Subject: RE: Planning Consultation on: LU/45/20/PL

Please find comments from Private Sector Housing below.

APPLICATION NO: LU/45/20/PL

Description of Works: Change of use of existing ground floor retail unit (B1Business) to 3
No. flats (C3 Dwelling houses).

Proposed Ground Floor / Block Plan

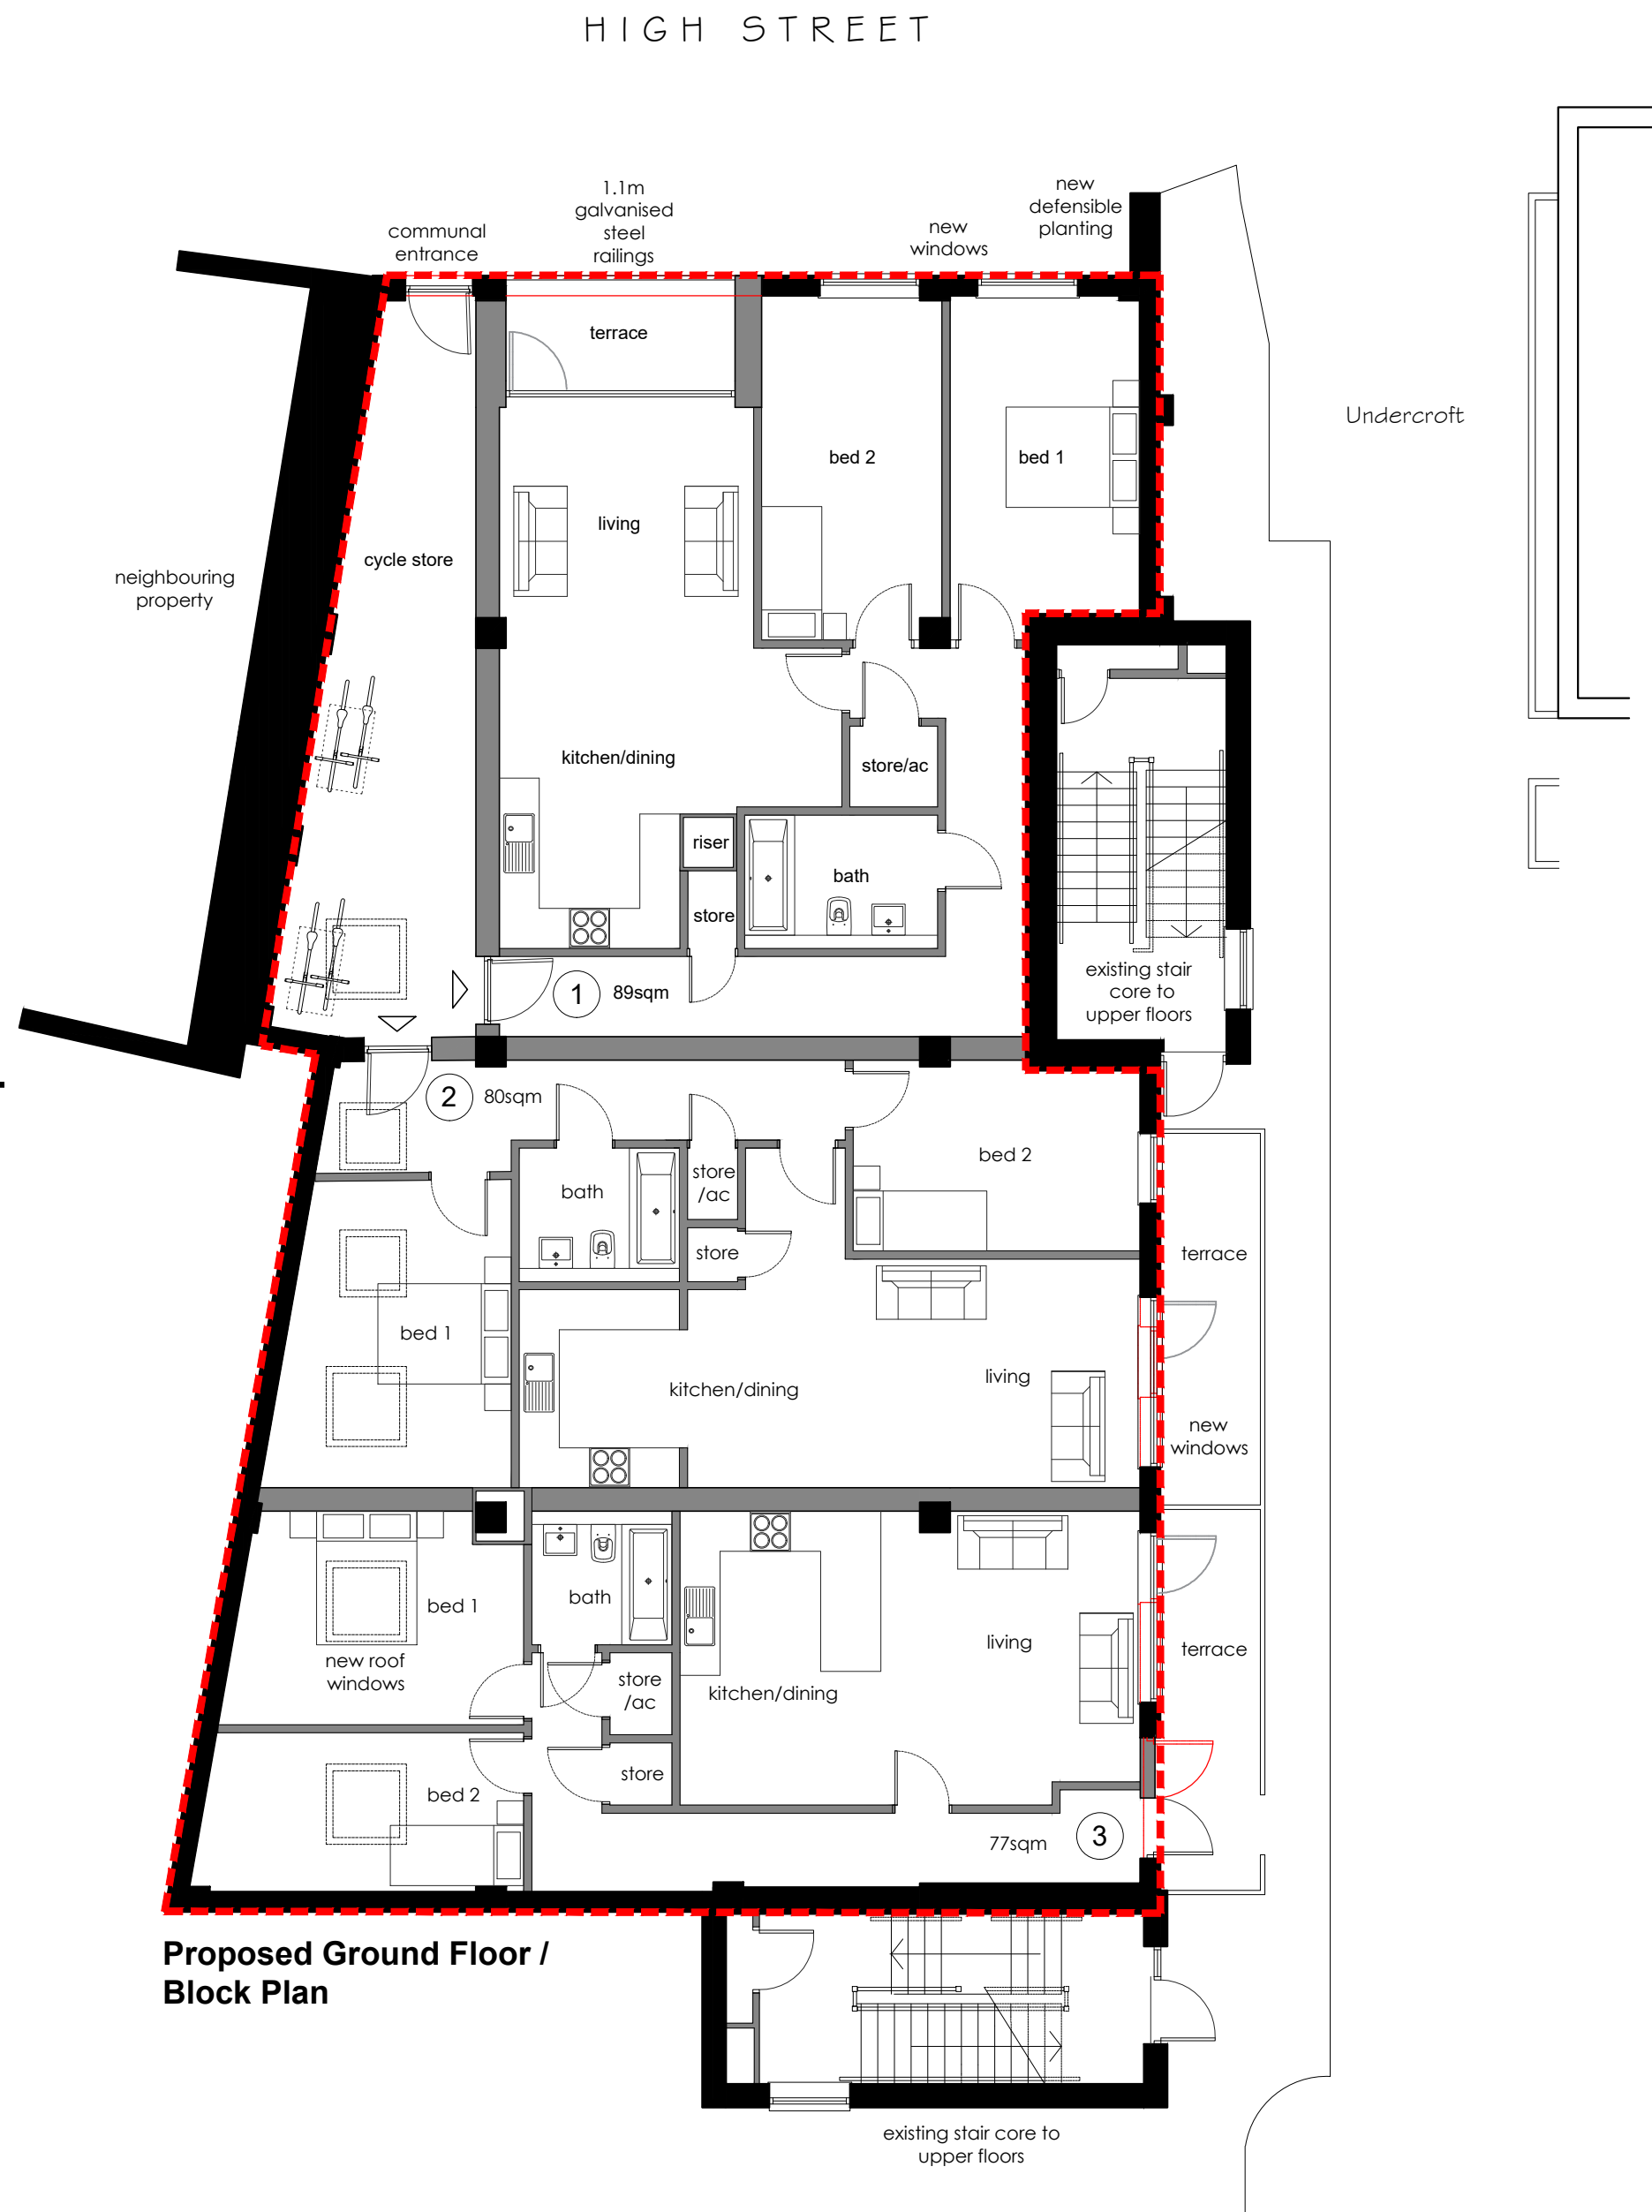
- 30min fire resisting escape route, which would include providing a 30 minute fire resisting and self-closing fire door to each flat entrance, except for flat 3 as this appears to have its own private entrance via the terrace

- A mixed Grade A, LD2 and Grade D1, LD3 fire system should be maintained and installed (this should already be present and will need to be extended to the ground floor flats)
Grade A, LD2 system:

- Interlinked detection throughout the escape routes
 - Interlinked heat detection to each flatGrade D1, LD3 system:
 - Non-interlinked mains-wired smoke alarms with integral tamper-proof battery back-up to each self-contained flat

- Any kitchens without windows for natural ventilation should have adequate mechanical ventilation
- Mechanical extraction should be provided to all bathrooms/shower rooms/en suites
